Morecambe Offshore Windfarm: Generation Assets Examination Documents

Marine Mammal Technical Note 1 (EIA)

Document Reference: 9.25

Rev 02

Figure 2.1 Ambient underwater noise following Wenz (1962) showing frequency dependency from different noise sources

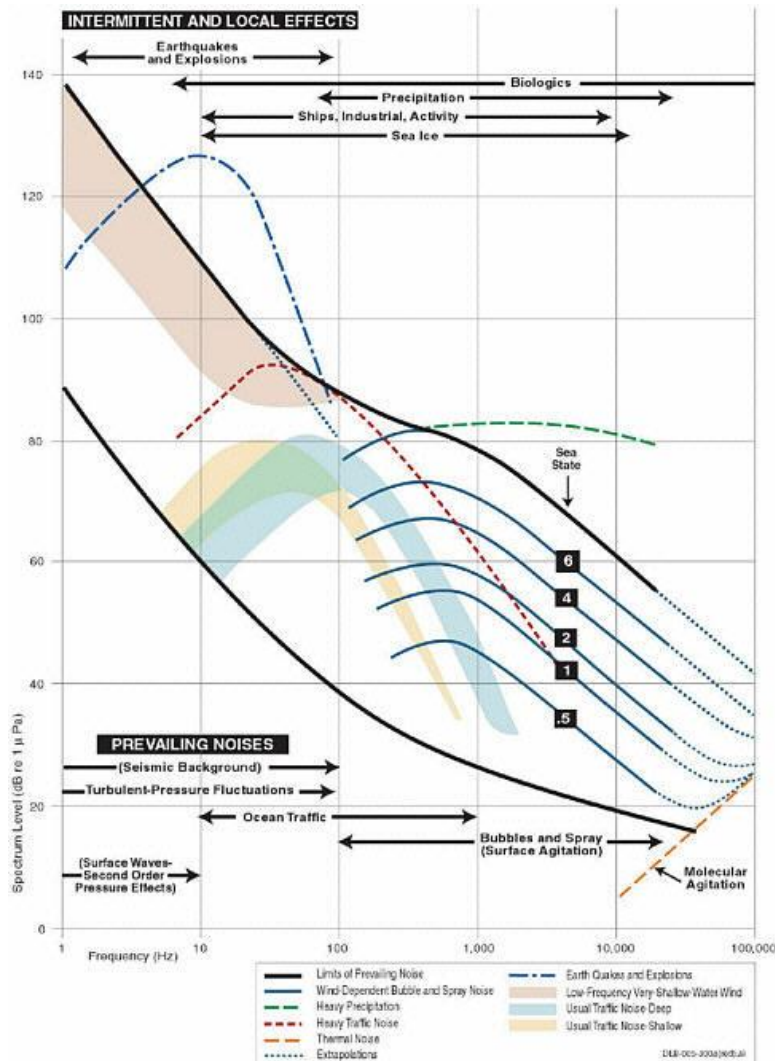
"The baseline noise levels have not been presented, despite the NPS requirement".

9. Typical underwater noise levels show a frequency dependency in relation to different noise sources; the classic curves are given in Wenz (1962) and are reproduced in **Figure 2.1** below. **Figure 2.1** shows that any unweighted overall (i.e., single-figure non-frequency-dependent) noise level is typically dependent on the very low frequency element of the noise. The introduction of a nearby anthropogenic noise source (such as piling or sources involving engines) will tend to increase the noise levels in the 100 Hz to 1 kHz region, but to a lesser extent will also extend into higher and lower frequencies.
